Re: Soil, Geology, and Geologic Hazard Study - Addendum  
Homestead at Sterling Ranch Filing No. 3  
El Paso County, Colorado  
Entech Job No. 221195

Colorado Geological Survey Review, December 6, 2022  
Homestead at Sterling Ranch Filing No. 3  
El Paso County, Colorado  
County File No. SP227

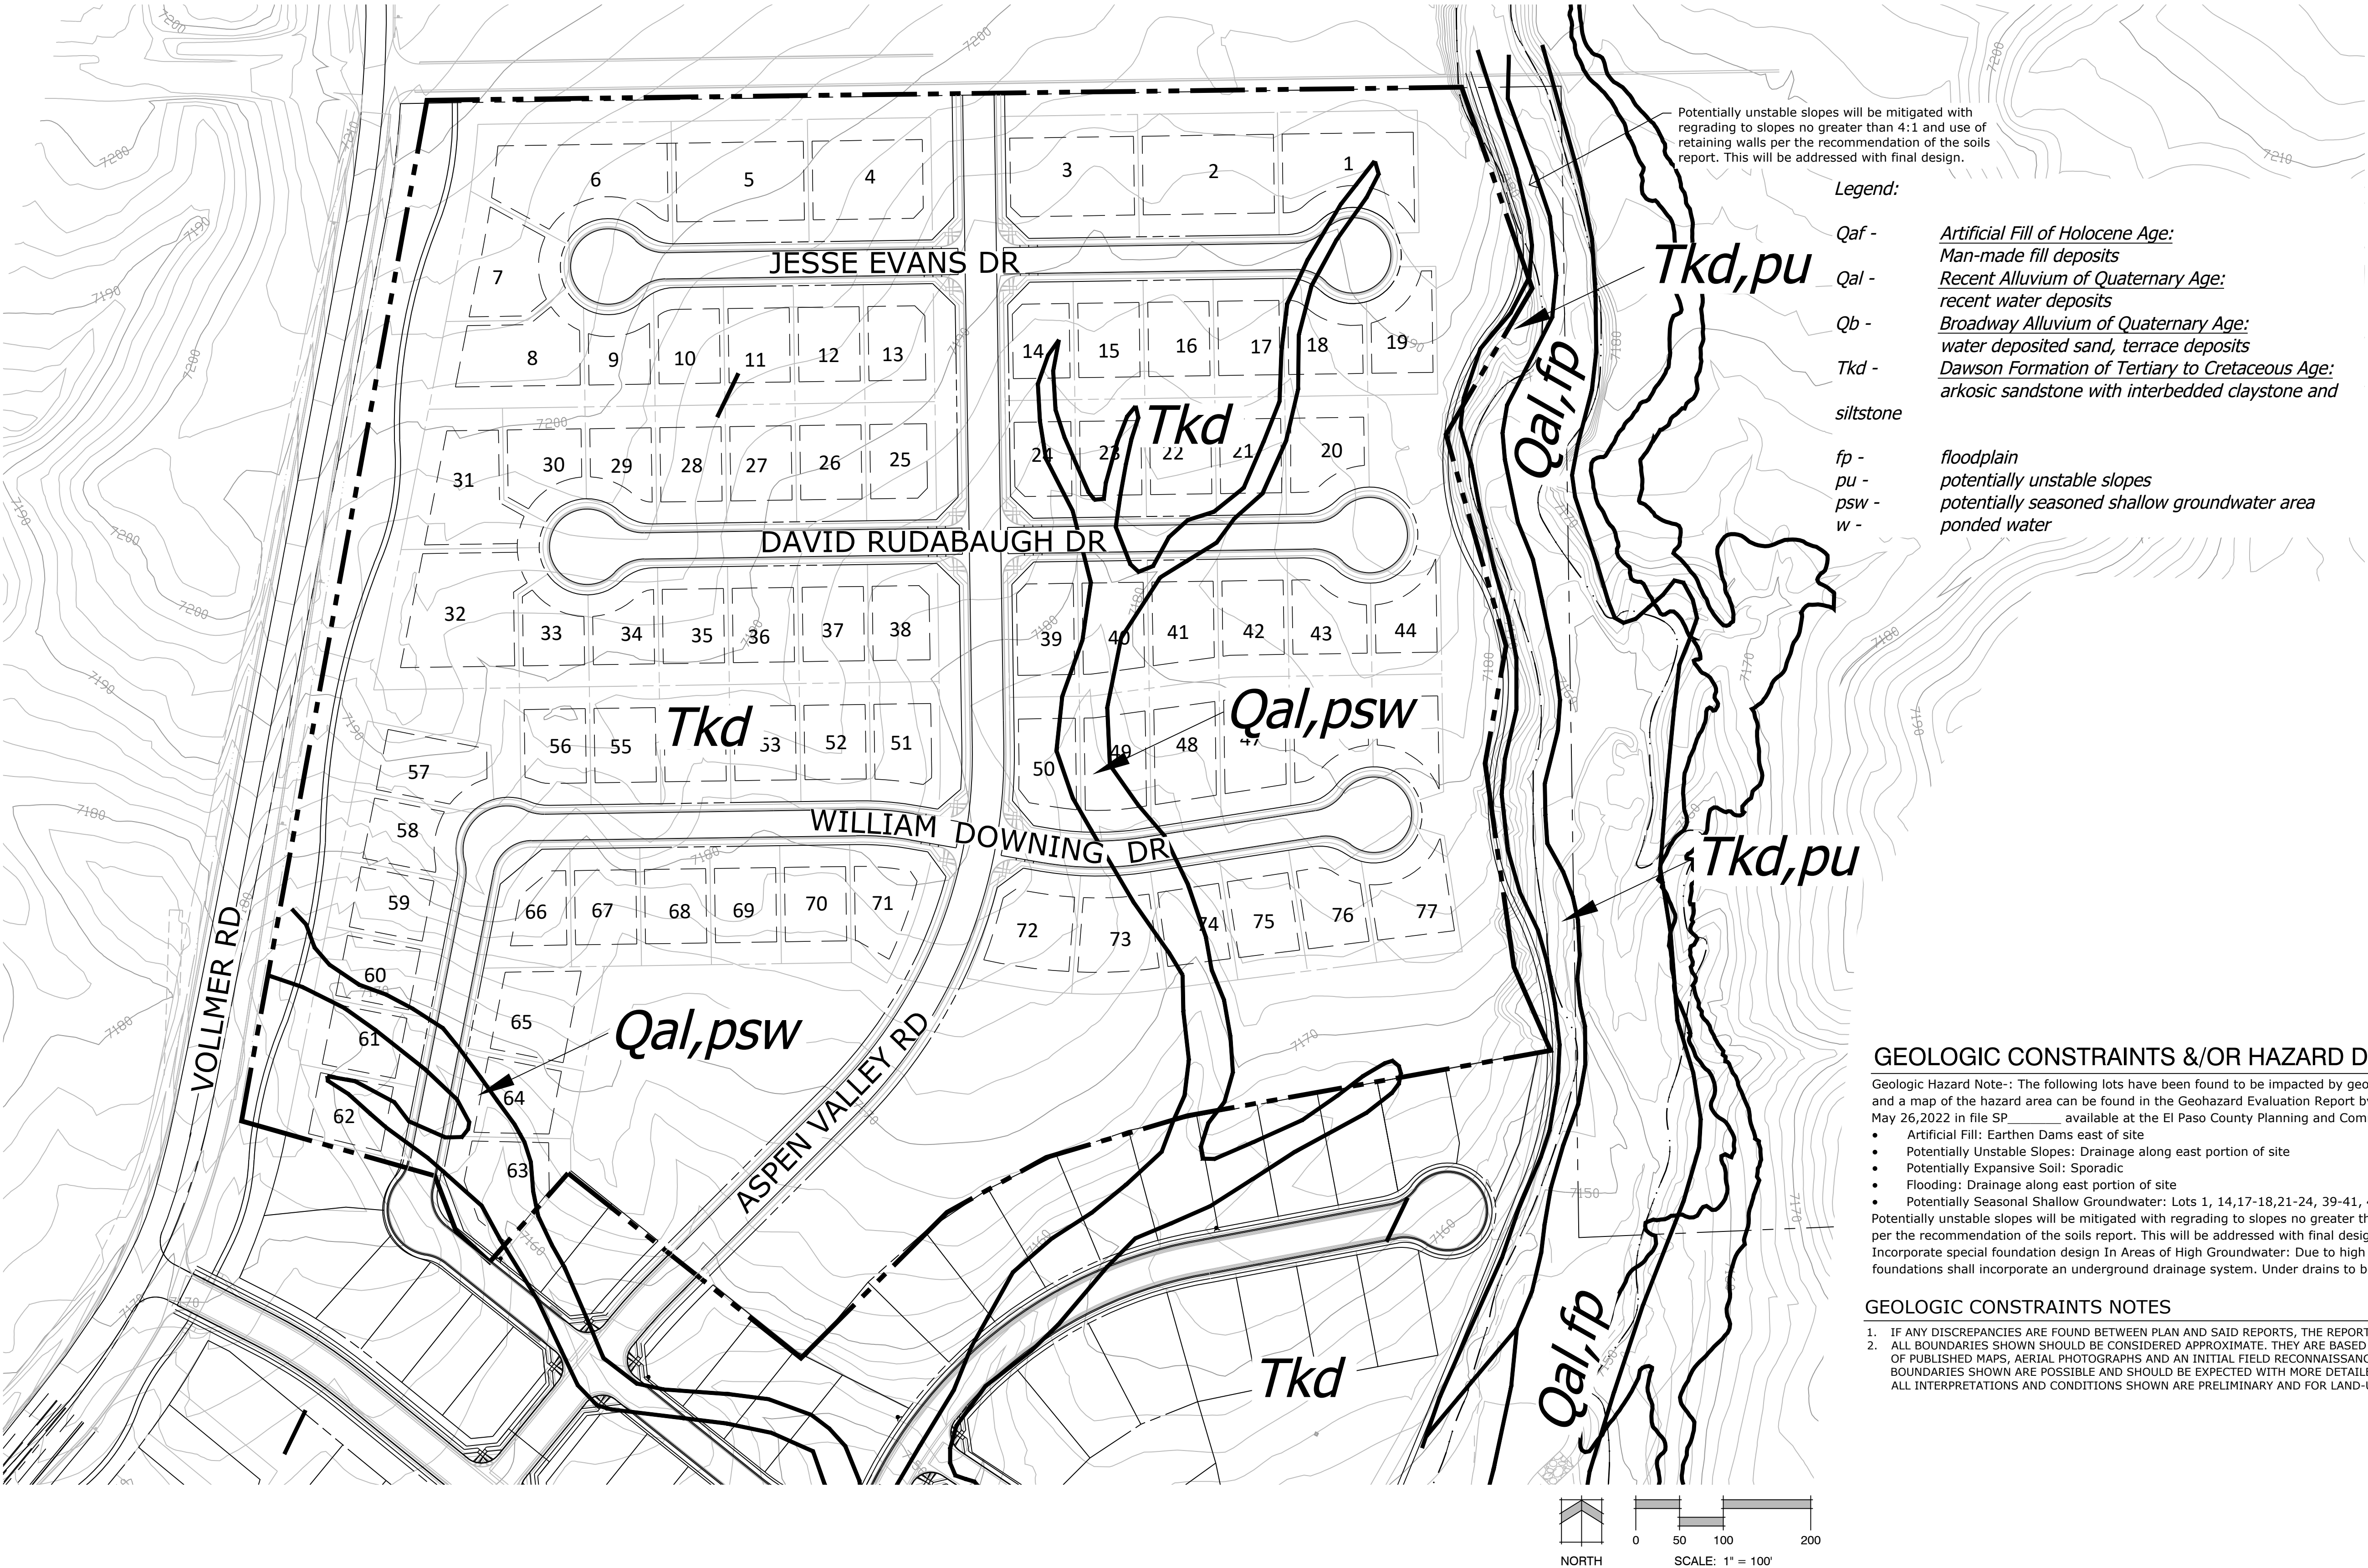
**CGS Comment:** *"Even with an underdrain system, basements or other below-grade habitable spaces may be impacted by shallow groundwater. The most positive approach to determining potential shallow groundwater impacts on any planned below-grade areas is with a groundwater monitoring program. A program should be conducted through the spring, summer, and fall to collect the data necessary to address potentially shallow groundwater, its seasonal fluctuation, and impacts on basement feasibility.... If basement or other below-grade areas are desired, CGS recommends that the additional investigations recommended by Entech (p.16) evaluate the seasonal fluctuations in shallow groundwater and the extent of mitigation expected with the planned underground drainage system."*

**Entech Response:** Additional site investigation will be conducted as final development plans and grading are prepared for the site. The mapped potentially seasonal shallow groundwater areas located on the site will likely be regraded during the site preparation. Additional investigation will be conducted across the site and within areas identified with the potential for seasonal shallow groundwater conditions. The scope of the investigation and recommended mitigations will be based on the proposed grading and the results of the future investigations.
